CITY OF ALBUQUERQUE

Re: Carlisle and Menaul
Traffic Impact Study (H16D083F)
Submittal dated March 4, 2025
Via email cvermillion@bhinc.com and ABQ-PLAN

**SITE PLAN AND CROSS SECTION
EXHIBIT**

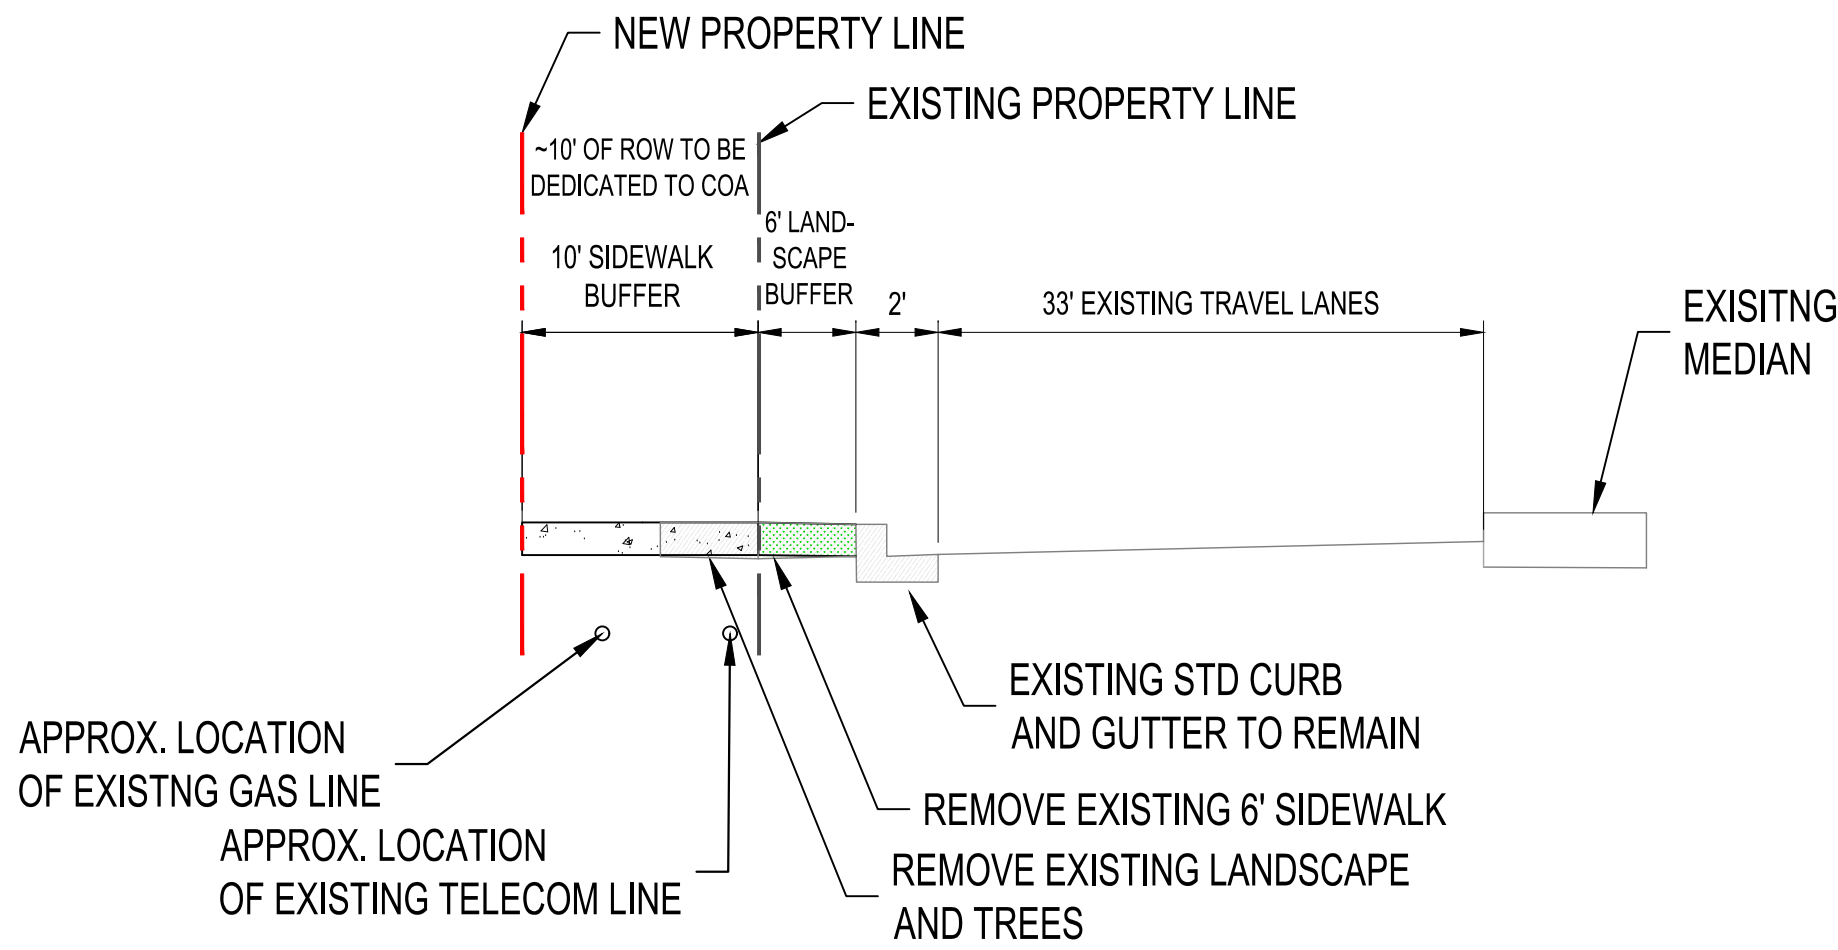
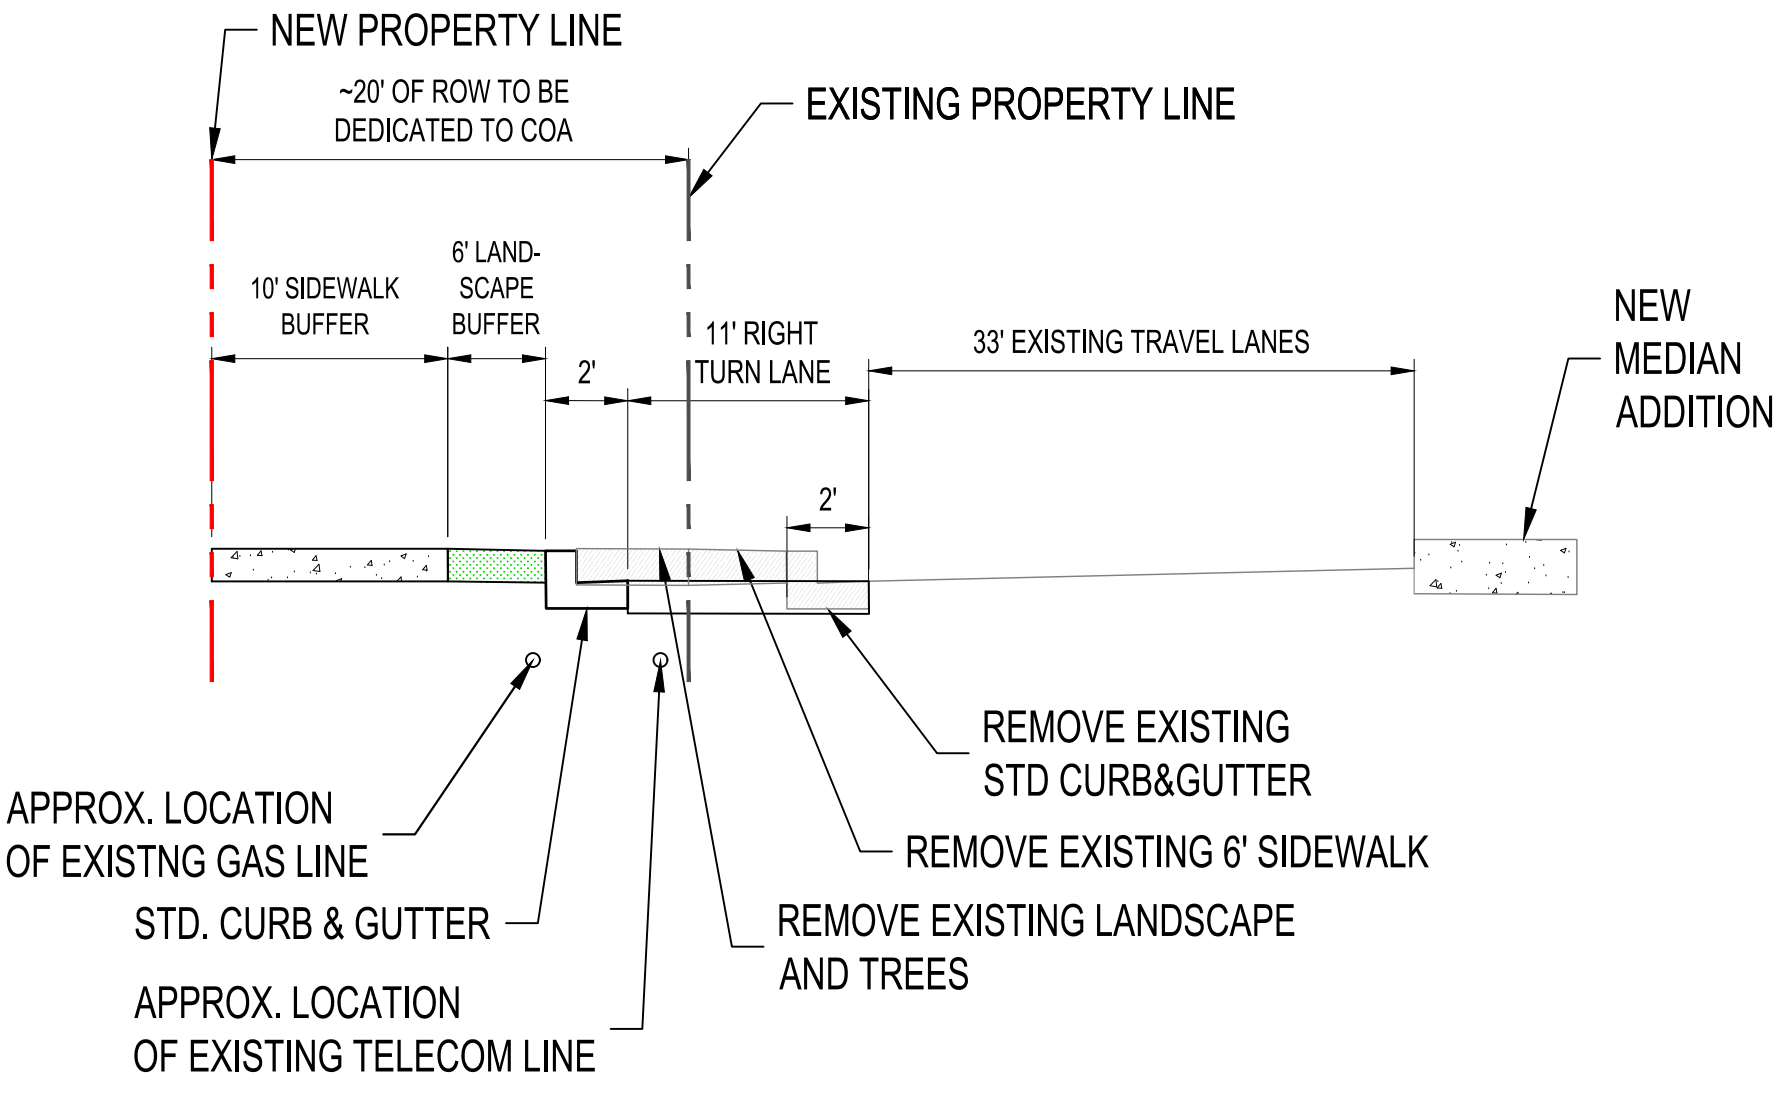
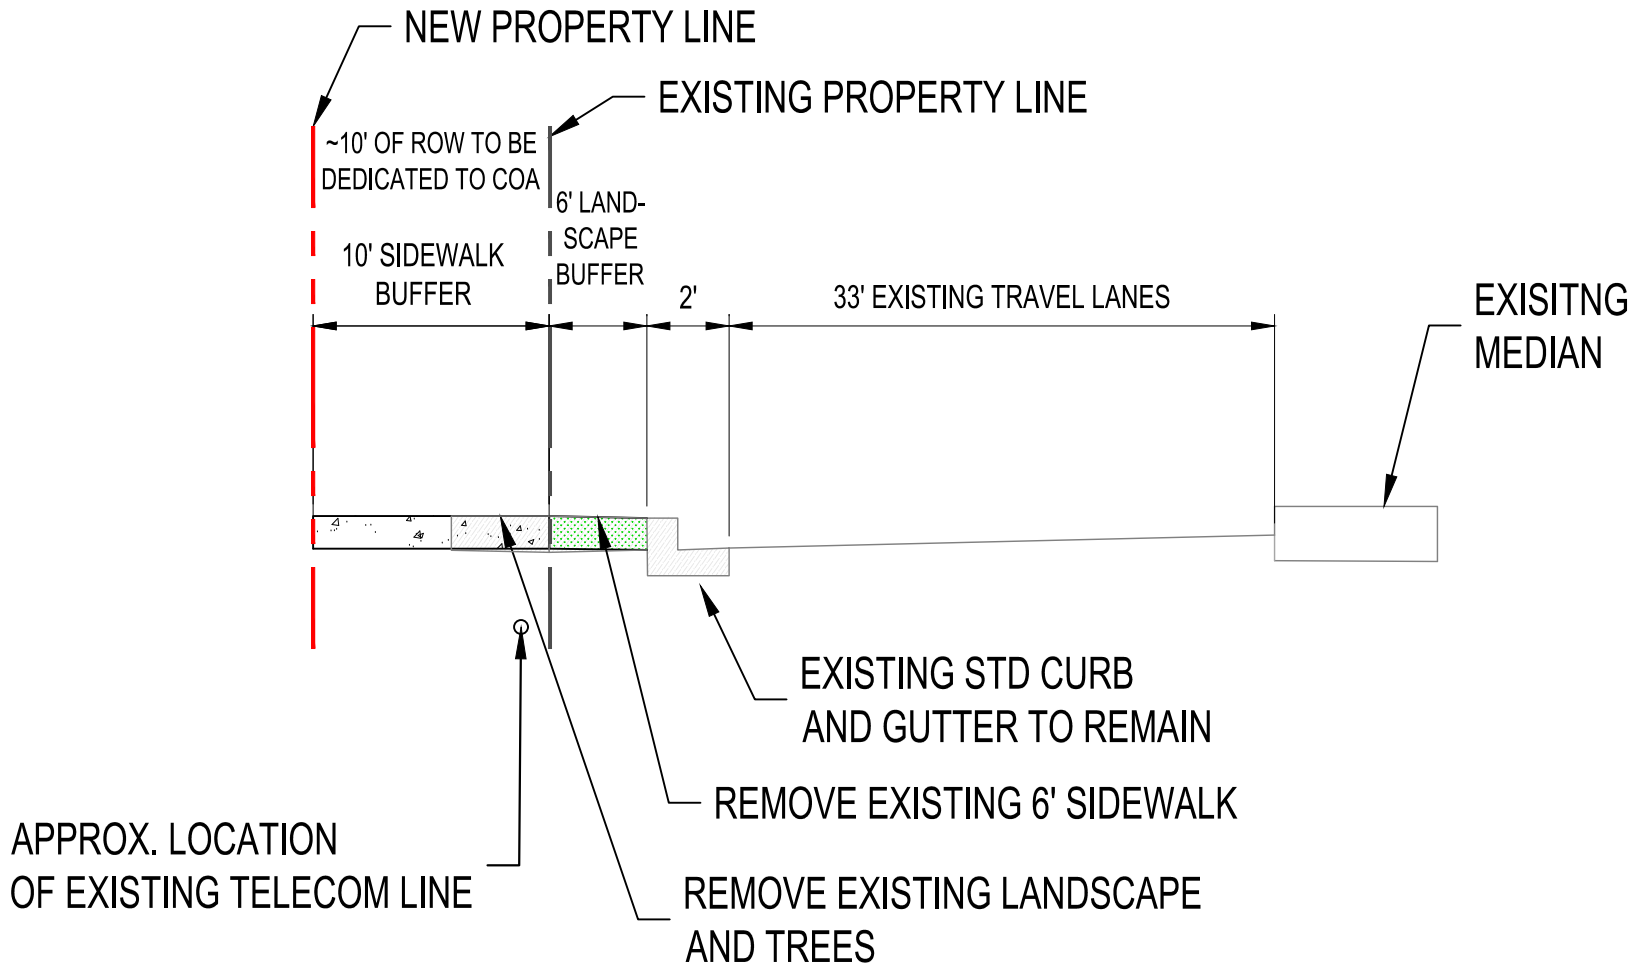
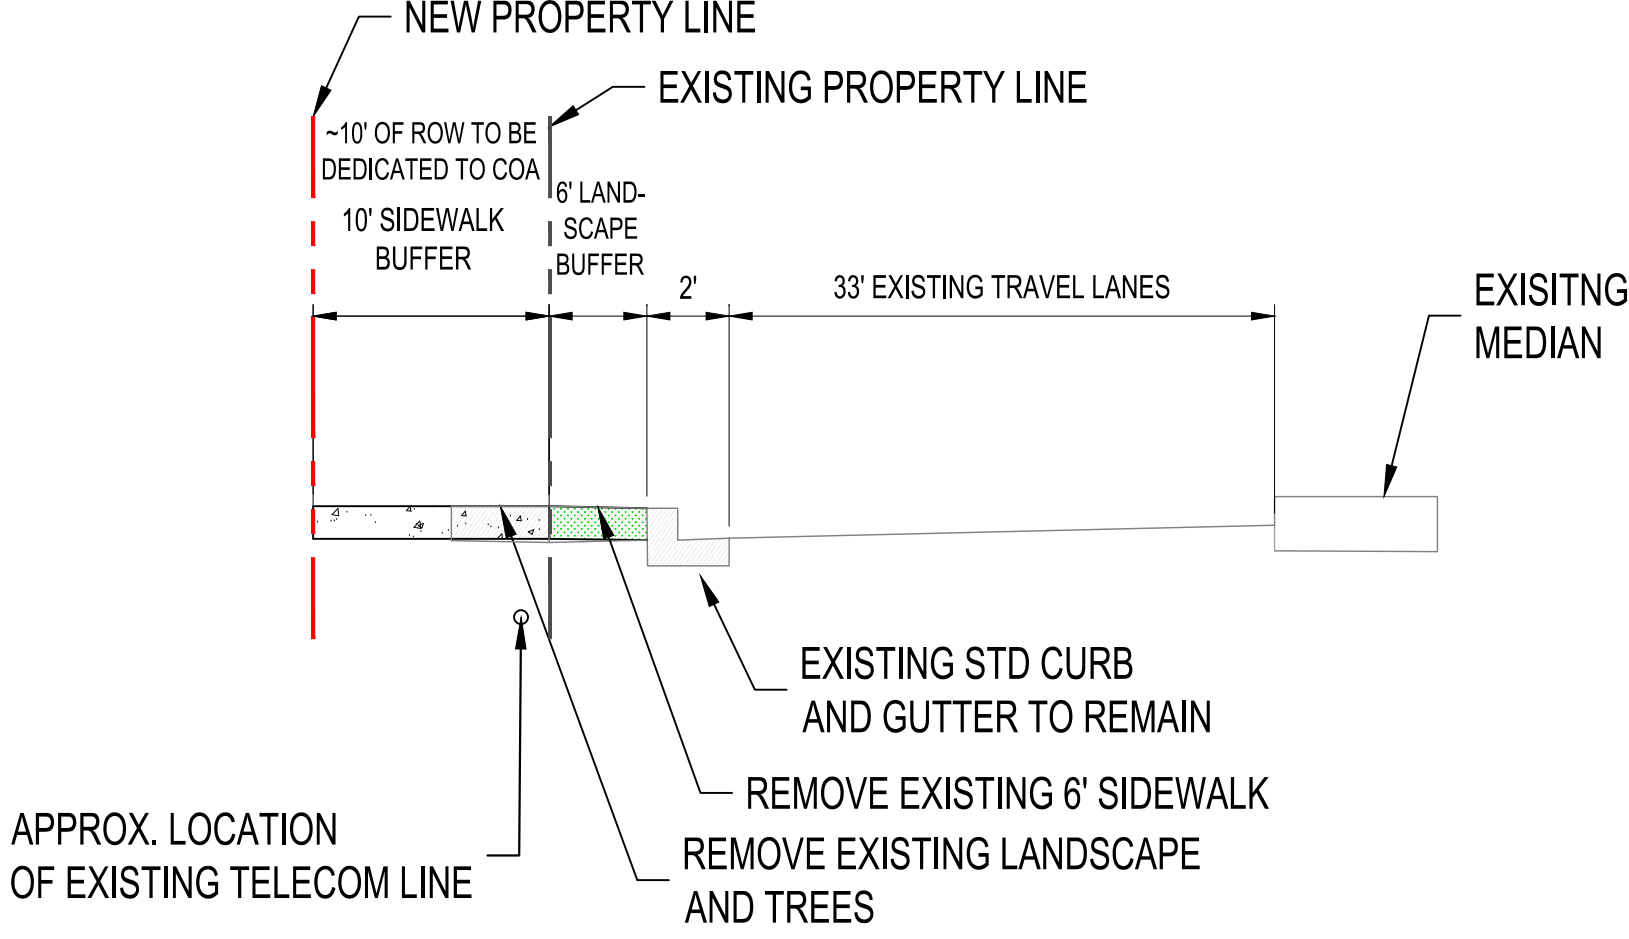
2. The response to previous comment #4, was to not construct a sidewalk buffer as it would increase the crossing distance at access points.

-Due to the southbound right-turn lane at Phoenix, a sidewalk buffer will decrease the crossing distance at Phoenix and Carlisle.

-It would increase the distance at Access 3, but a pedestrian refuge or similar countermeasure would help.

-Constructing the sidewalk buffer would improve safety along the Carlisle Blvd frontage.
